RE: ENVIRONMENTAL ASSESSMENT FOR MP 11_0046 - STAGE 3, 61 MOBBS LANE, EPPING.

ATTACHMENT A

1 SECTION - Bldg 15-16 & 11
1 : 200

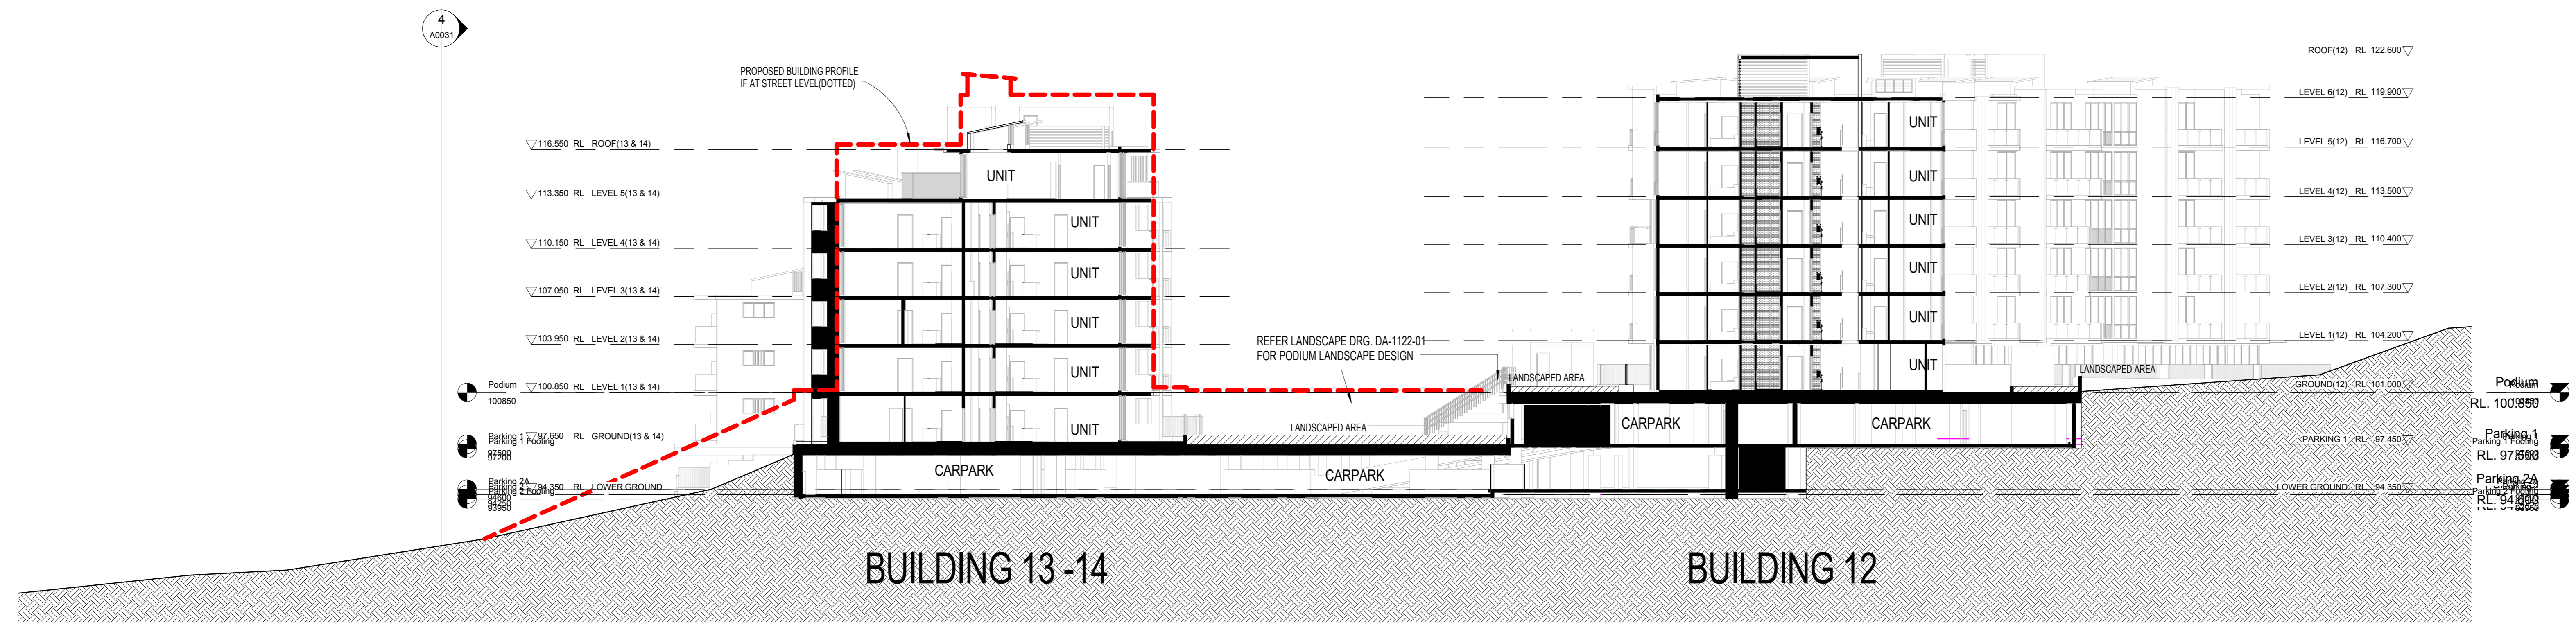
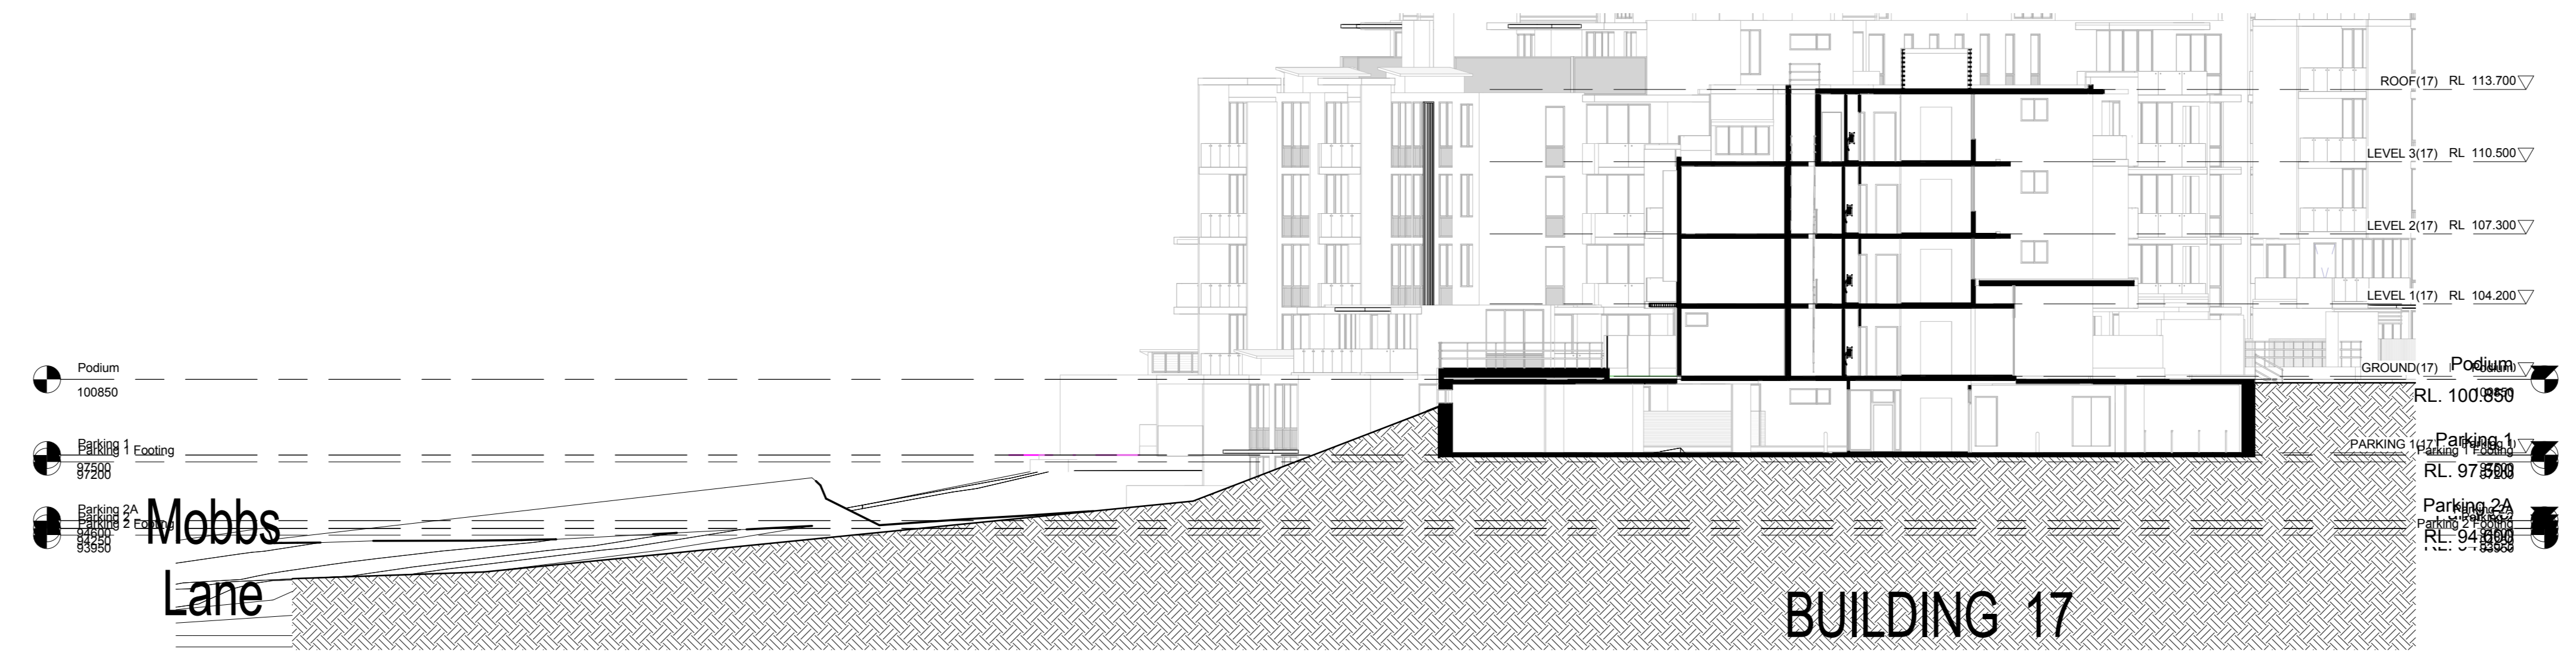
- f. No plans have been provided that show the finished levels and treatment of the podium areas.
- g. A section should be provided through buildings 11 and 15/6 and another through buildings 12 and 13/14 to allow an understanding the how the parking, podiums, buildings and topography relate. These sections are to identify the original ground level (prior to any early works) and the finished ground level after the early works.

Inadequate information is provided to allow an assessment of the proposed height of the buildings, particularly in relation to how far above natural and finished ground levels the podiums will be and how they will be treated.
